MEMORANDUM

DATE: October 10, 2018

SUBJECT: SP-18-002 – The Retreat at Timber Ridge
Fourth Submittal
CCES Drainage Responses – South Report (Red)

## Culvert Crossing at DP 10

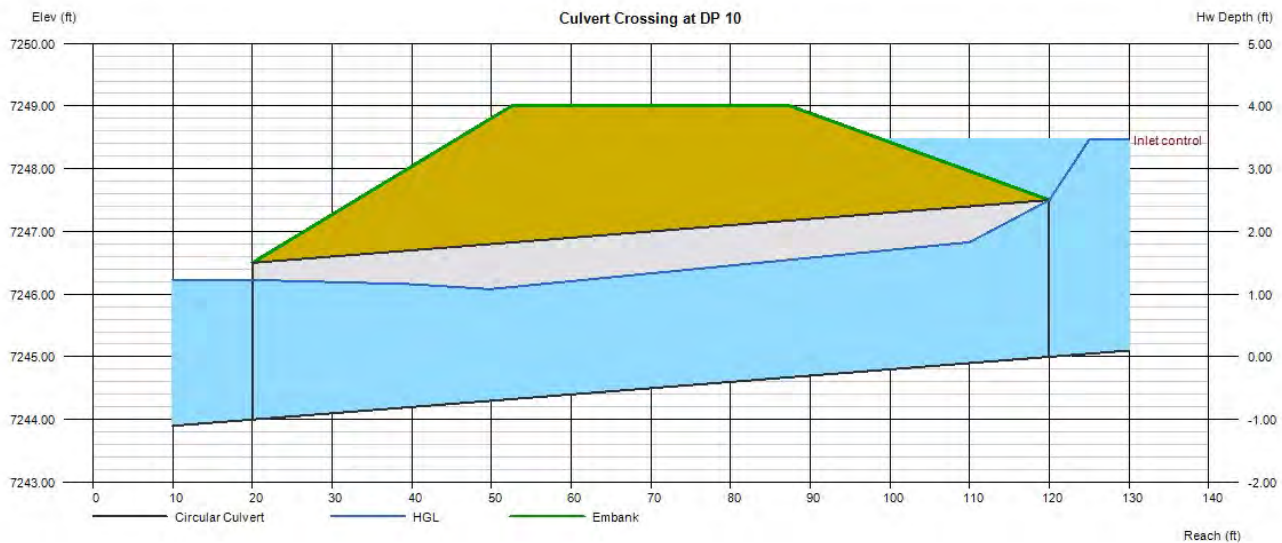
- b. Provide headwater calculations for the culverts crossing Vollmer Road and those capturing flows from the east of the property. Show any necessary ponding easements for those on the east side. Partially resolved; provide calculations for the culverts on the east side. (south) **Unresolved Culvert calculations now provided for culverts along east side**

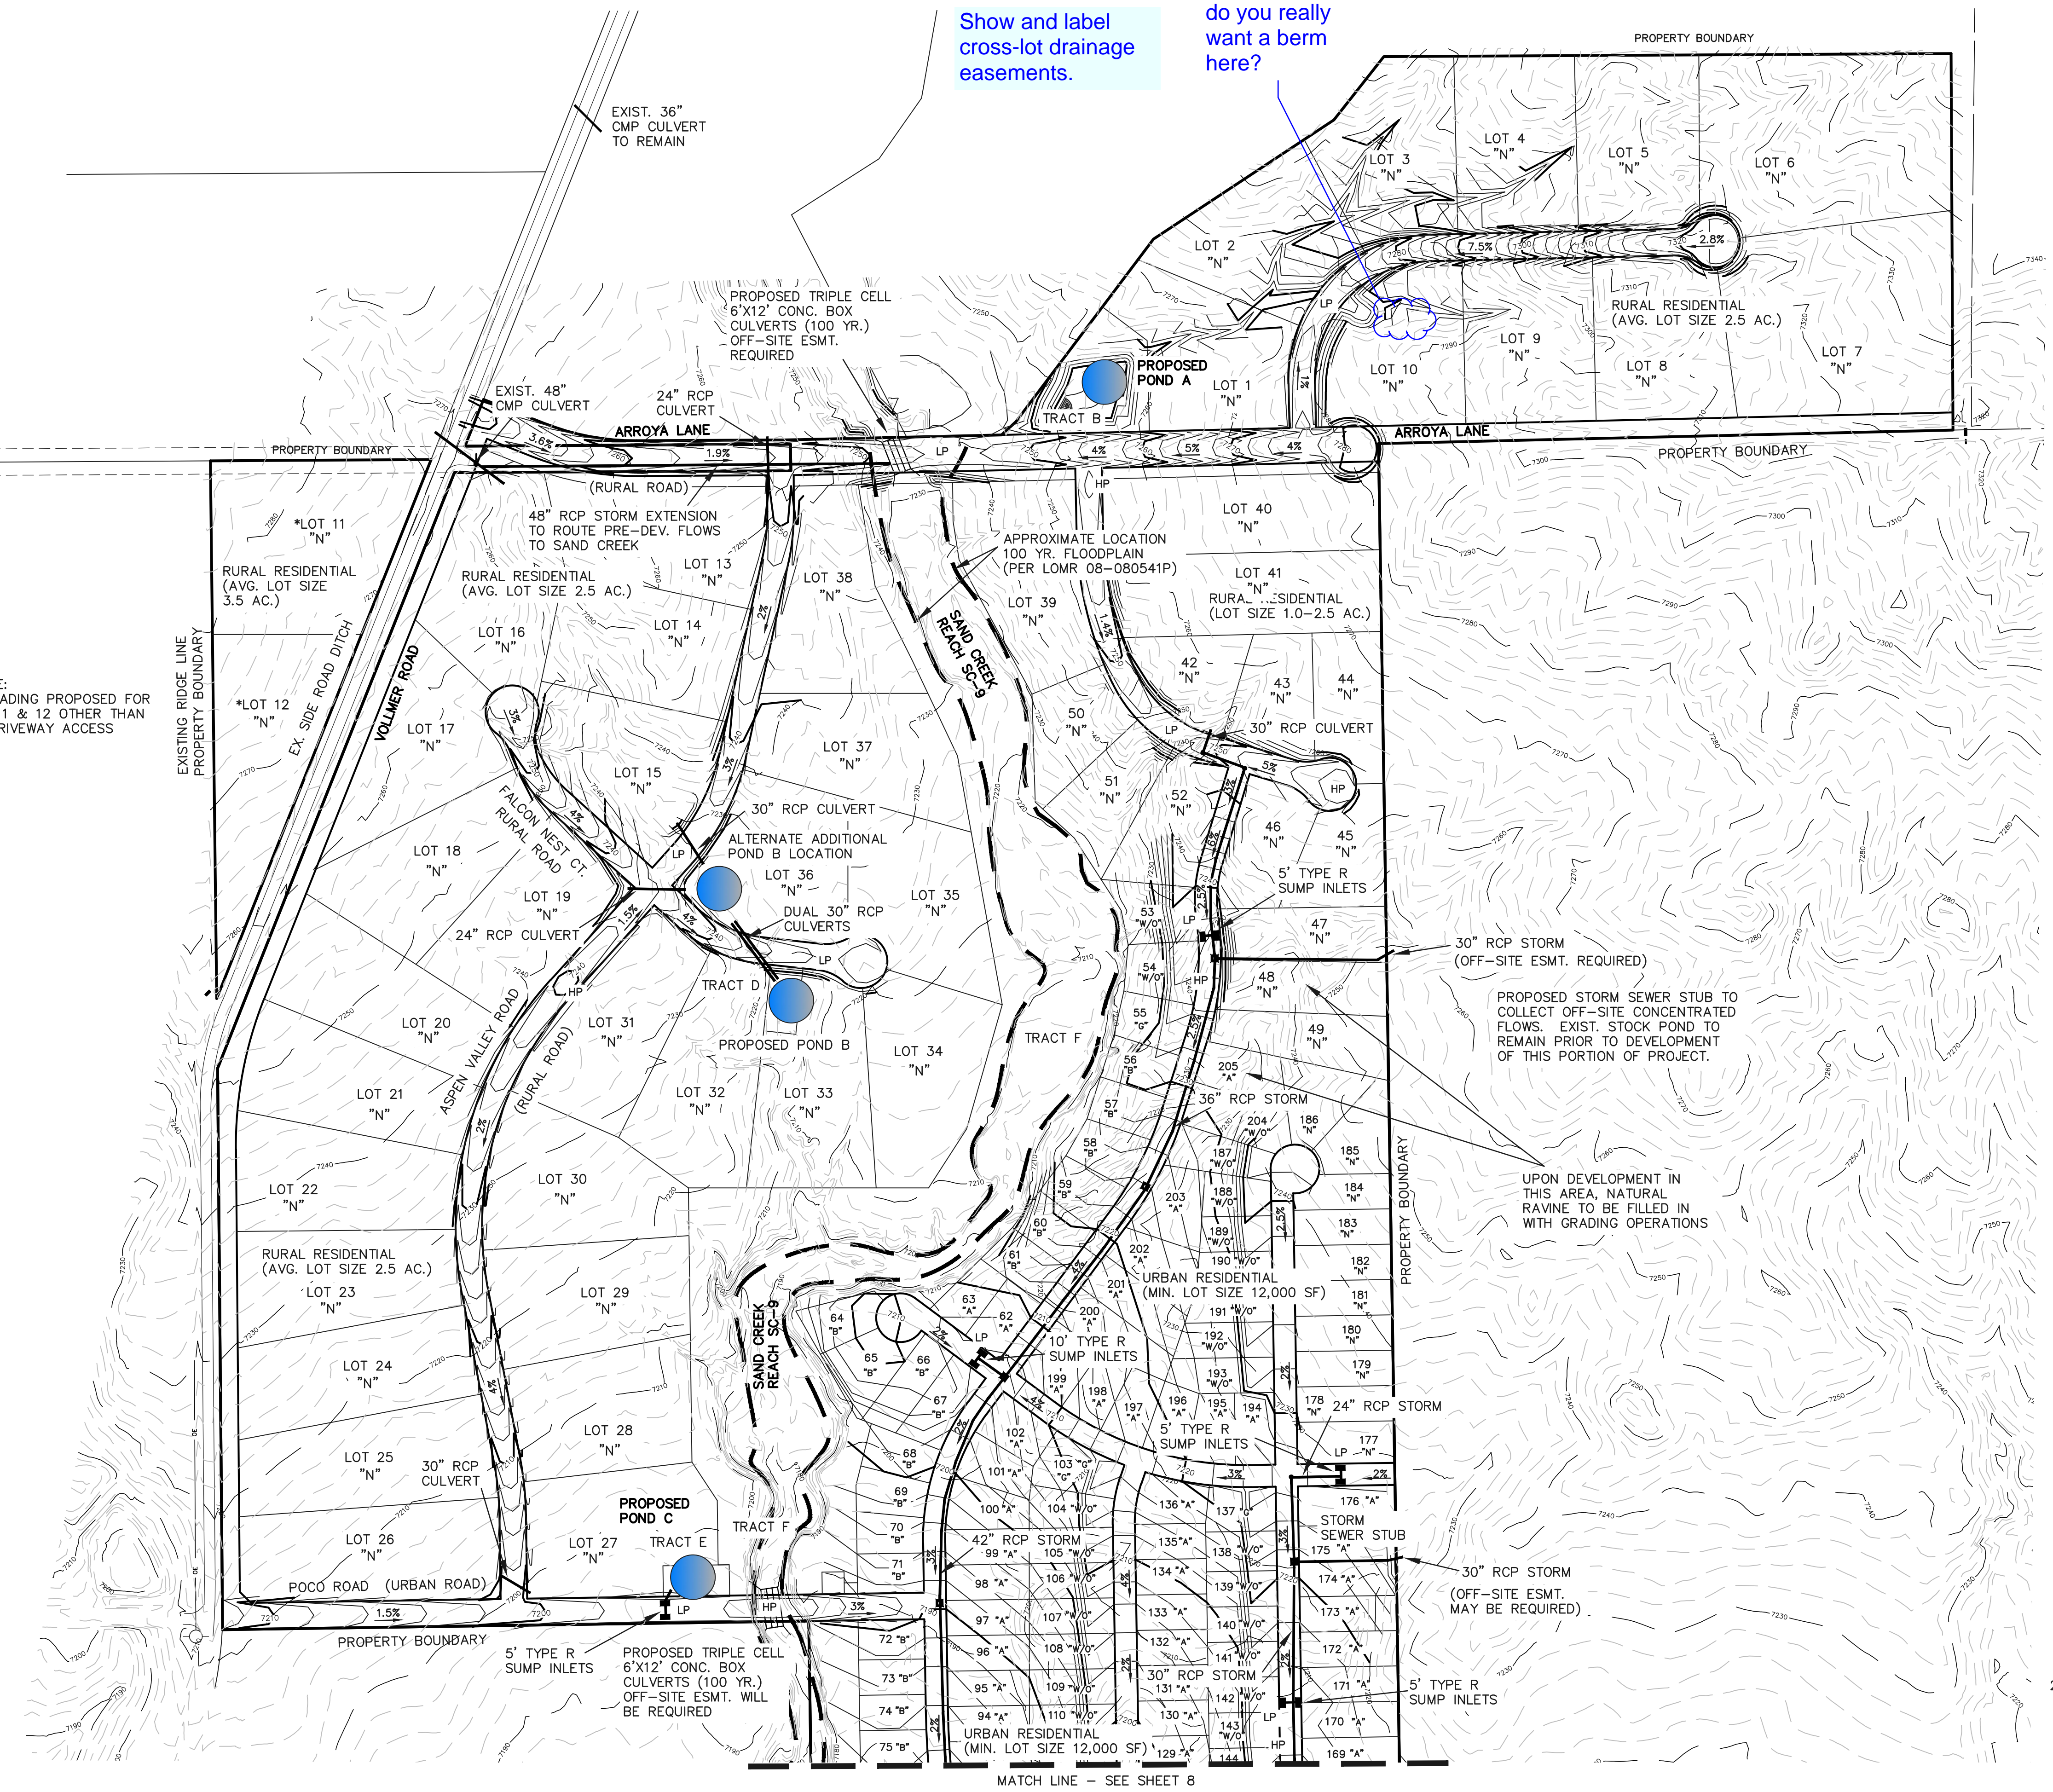
1. Ensure that all checklist items are provided (reference planning comments and redlines). Partially resolved; see updated redlines. **Partially resolved;**
 - a. See remaining redlines. **See updated redlines (sheet 7) and PDR comment #8.e, below. Revised PP Grading sheets 7 and 8**
 - b. **Resolved**
 - c. **Resolved**
2. through 6 – **Resolved**

- e. Provide an informational overall grading plan, including proposed WQCV facilities. This can be within the south PDR or standalone. **Partially resolved; see redlines on sheet 7 of the Preliminary Plan. See revised Preliminary Plan sheet 7 and revised developed drainage map.**
